Planning Inspectorate

Our Ref: EN020027

Application by National Grid Electricity Transmission (NGET) for an order granting development consent for the Norwich to Tilbury project

Advice following issue of decision to accept the application for examination

Drawing Number: 10059280-ARC-EHR-ZZ-DR-ZZ-00432	Revision: A
--	----------------

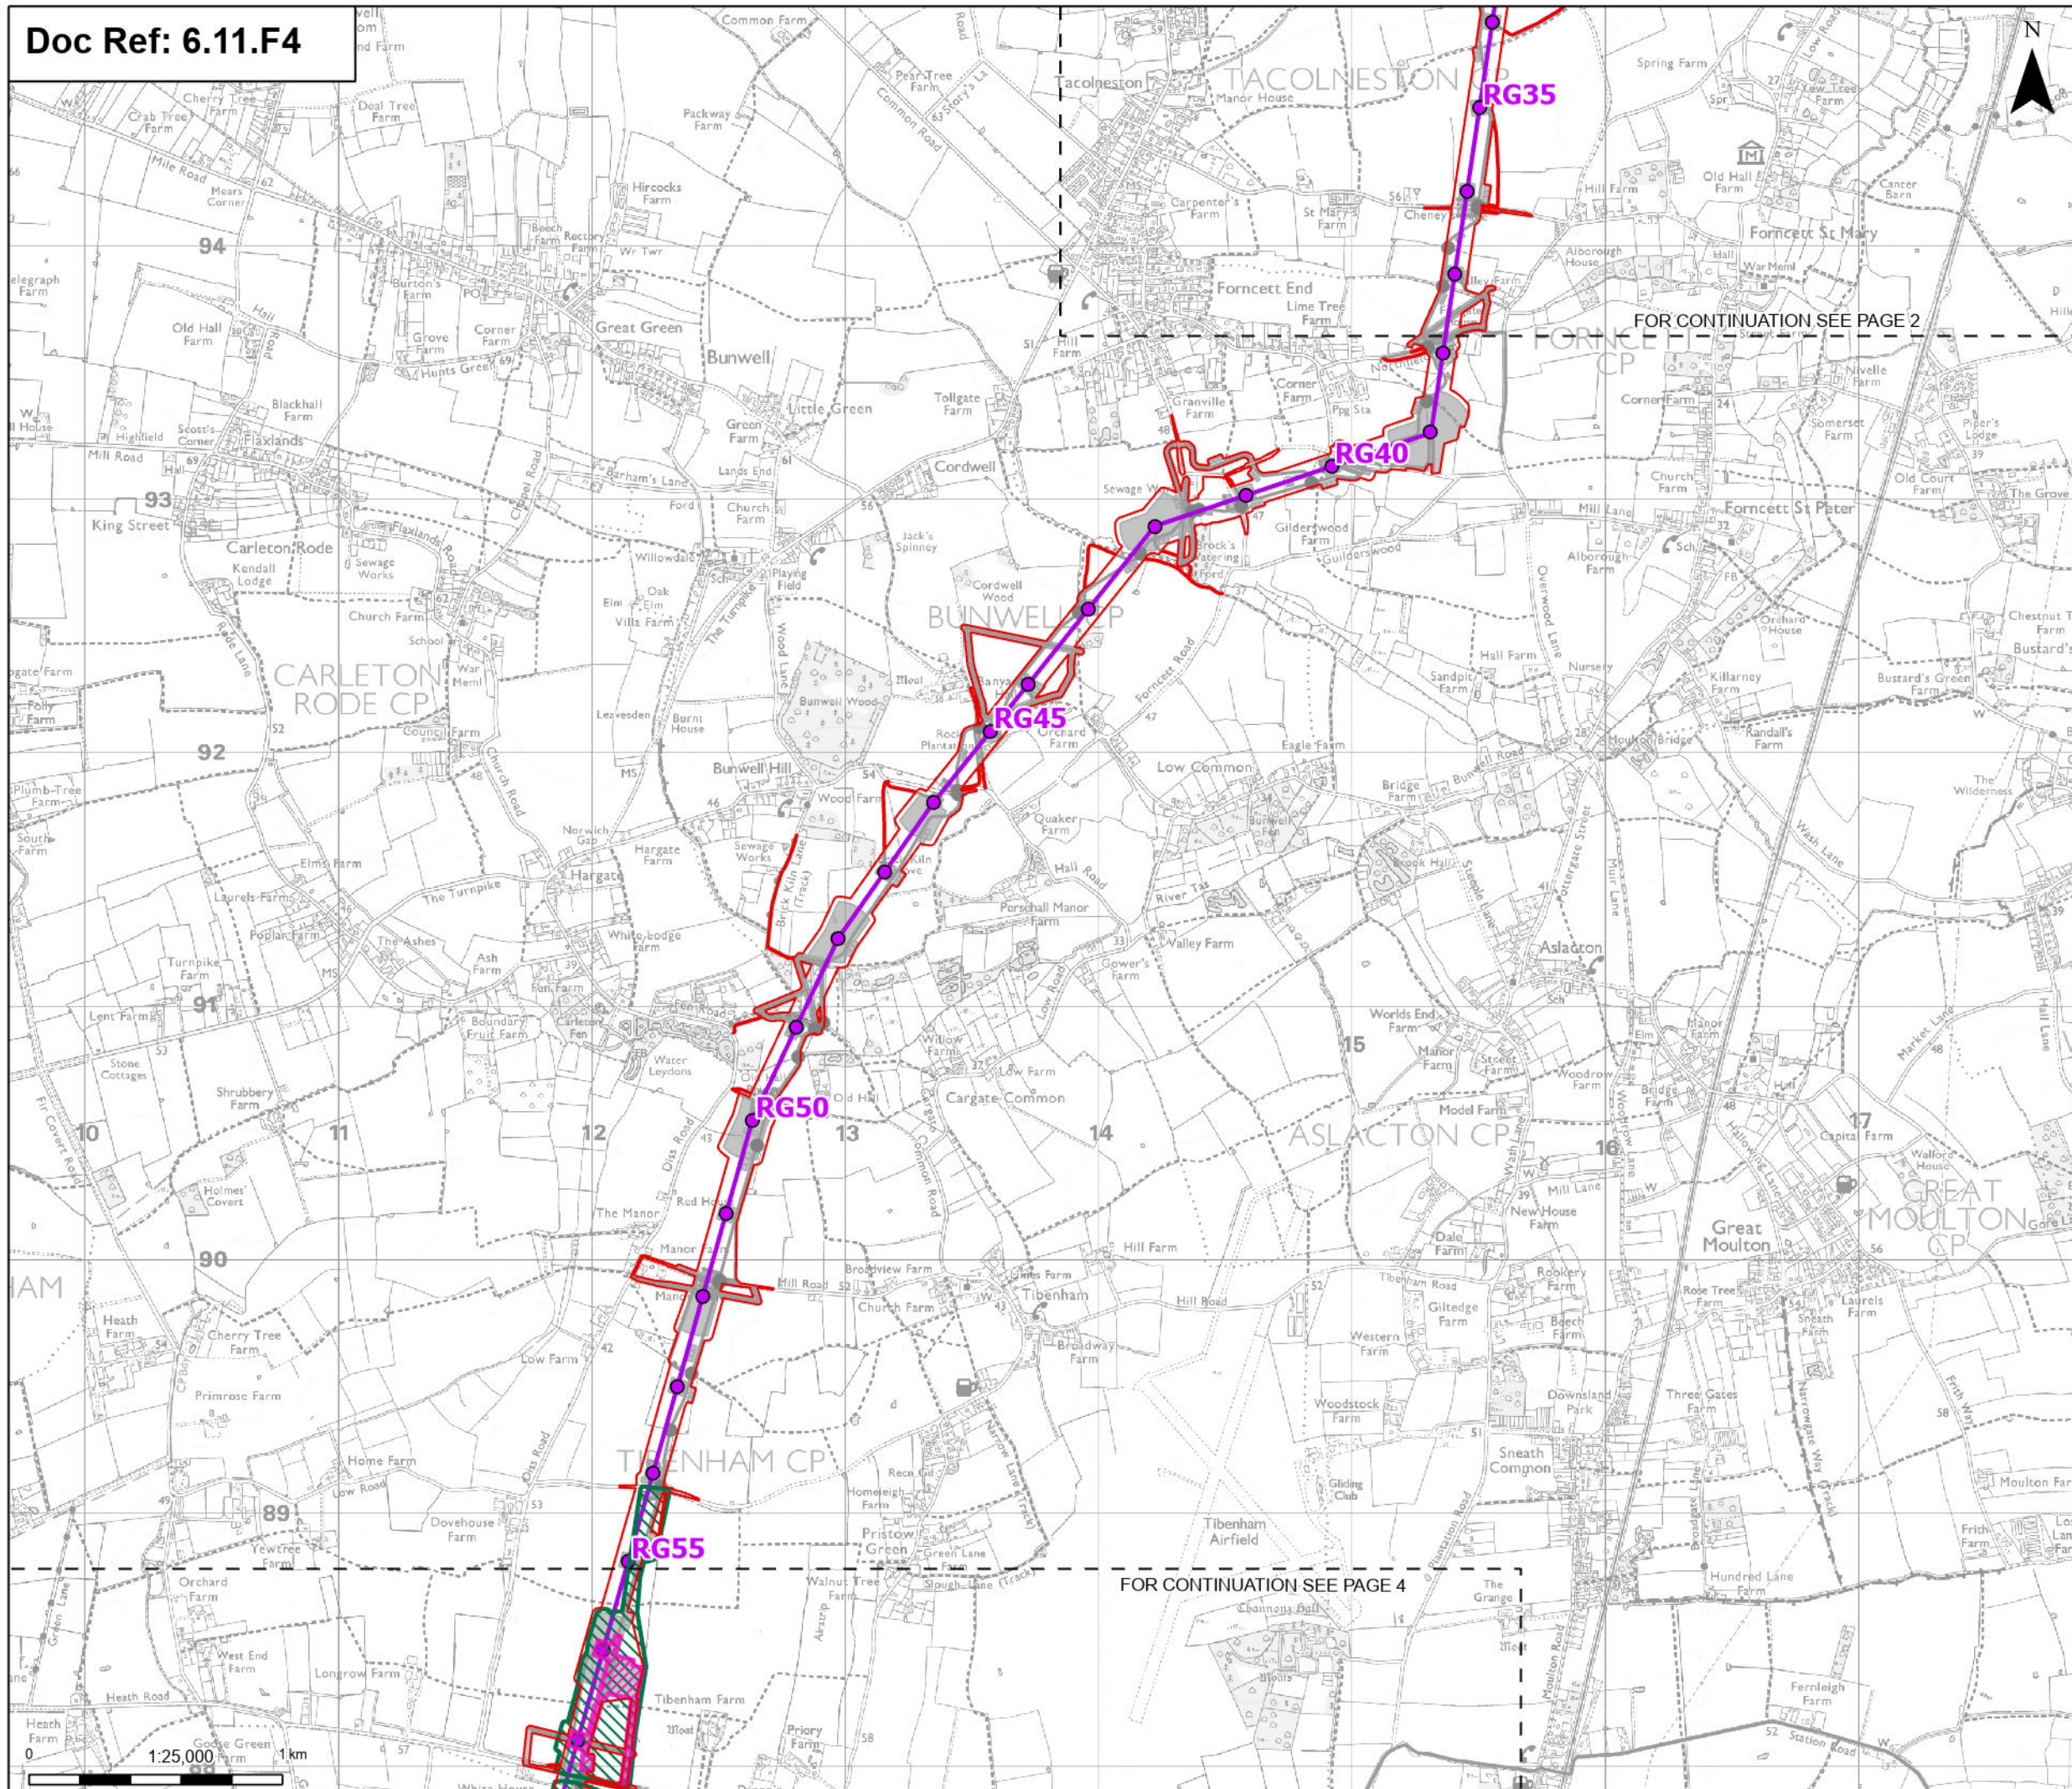
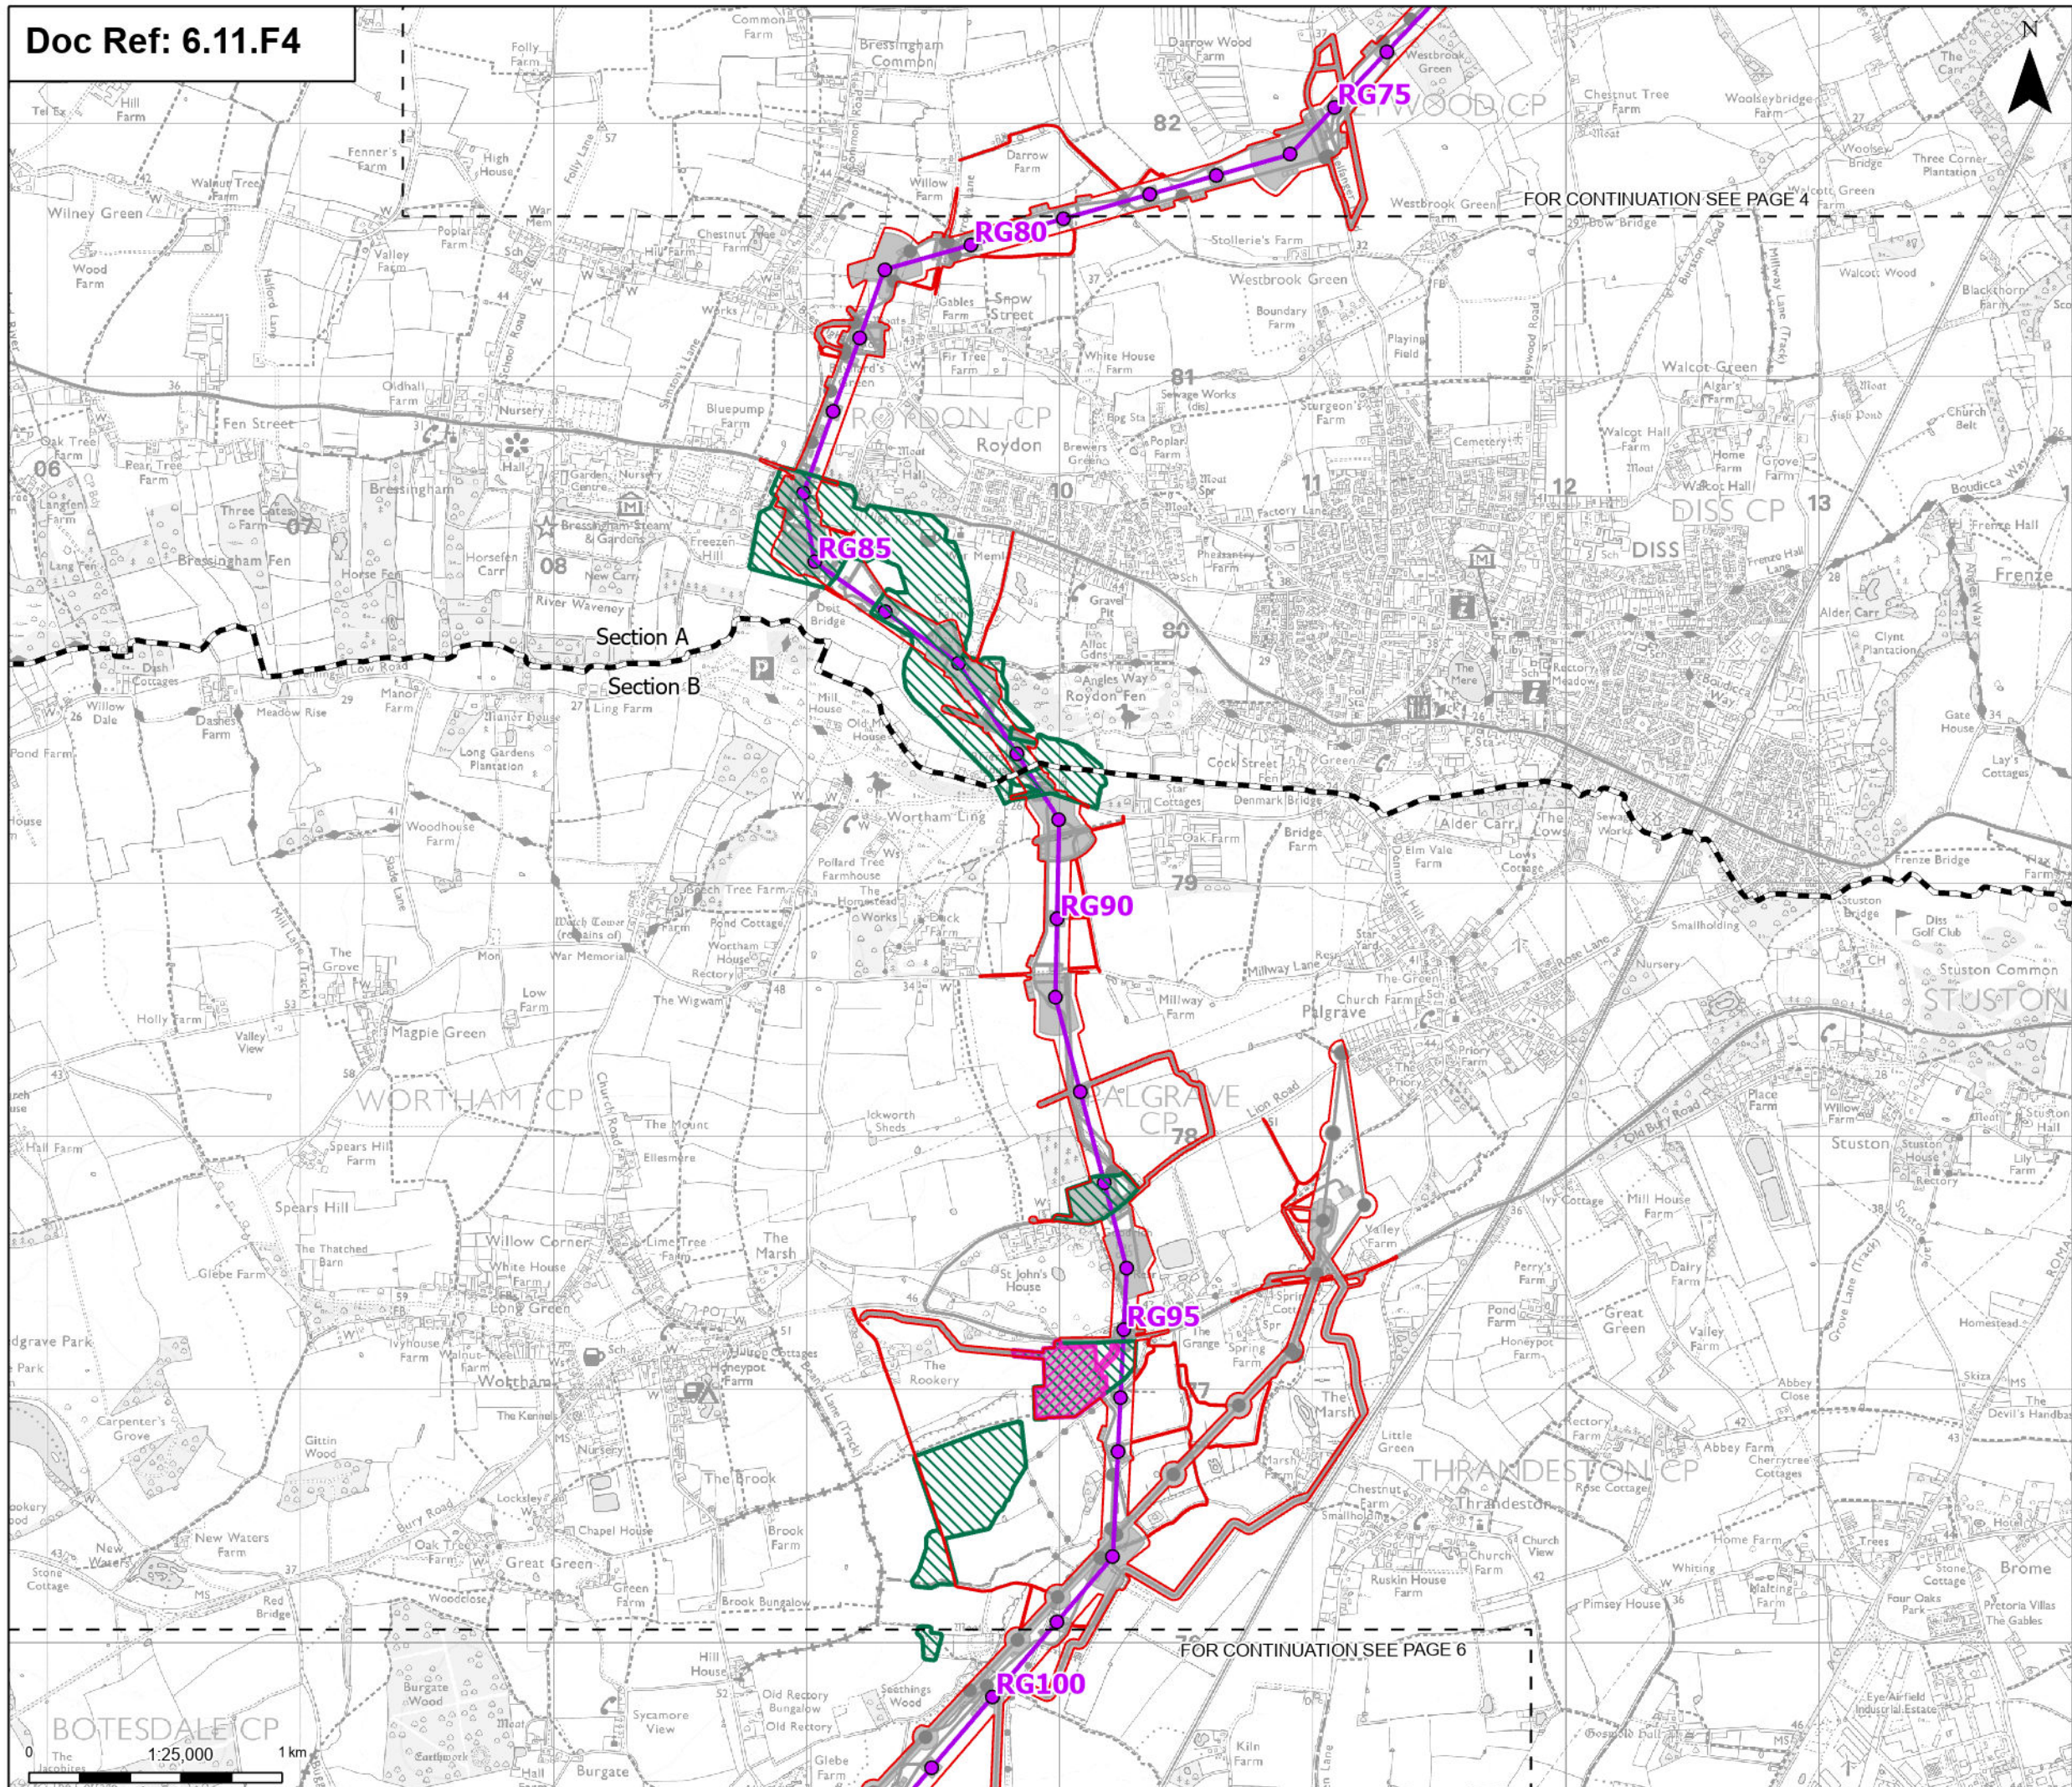
The pre-application engagement with Historic England and the relevant Councils since November 2023 regarding archaeological evaluation fieldwork is noted by the Planning Inspectorate, including the agreement of certain areas as ‘priority areas’ where geophysical surveys commenced in summer 2023 and trial trenching since Autumn 2024. The results of this fieldwork are contained within Appendices 11.3, 11.4, and 11.5 and incorporated in Section 11.5 to inform the baseline for assessment. It is noted that archaeological work on these areas and upon ‘phase 2 areas’ is ongoing and will continue into 2026, and that this approach has been agreed with the relevant statutory bodies. Table 11.2 of chapter 11 of the ES details these works to a certain degree, with a map of priority areas included in figure 11.4. It is noted that results from these further works is programmed to be submitted at various times: November 2025 prior to the start of the Examination; shared and agreed with Stakeholders early in 2026; and throughout 2026.

The Planning Inspectorate advises the applicant provides further clarification on such works in terms of details of the nature and location of the further works, and how and when the results will be submitted (see below regarding updates to the ES). It would also be beneficial if the results and analysis were submitted together where possible to avoid the drip feeding of information.
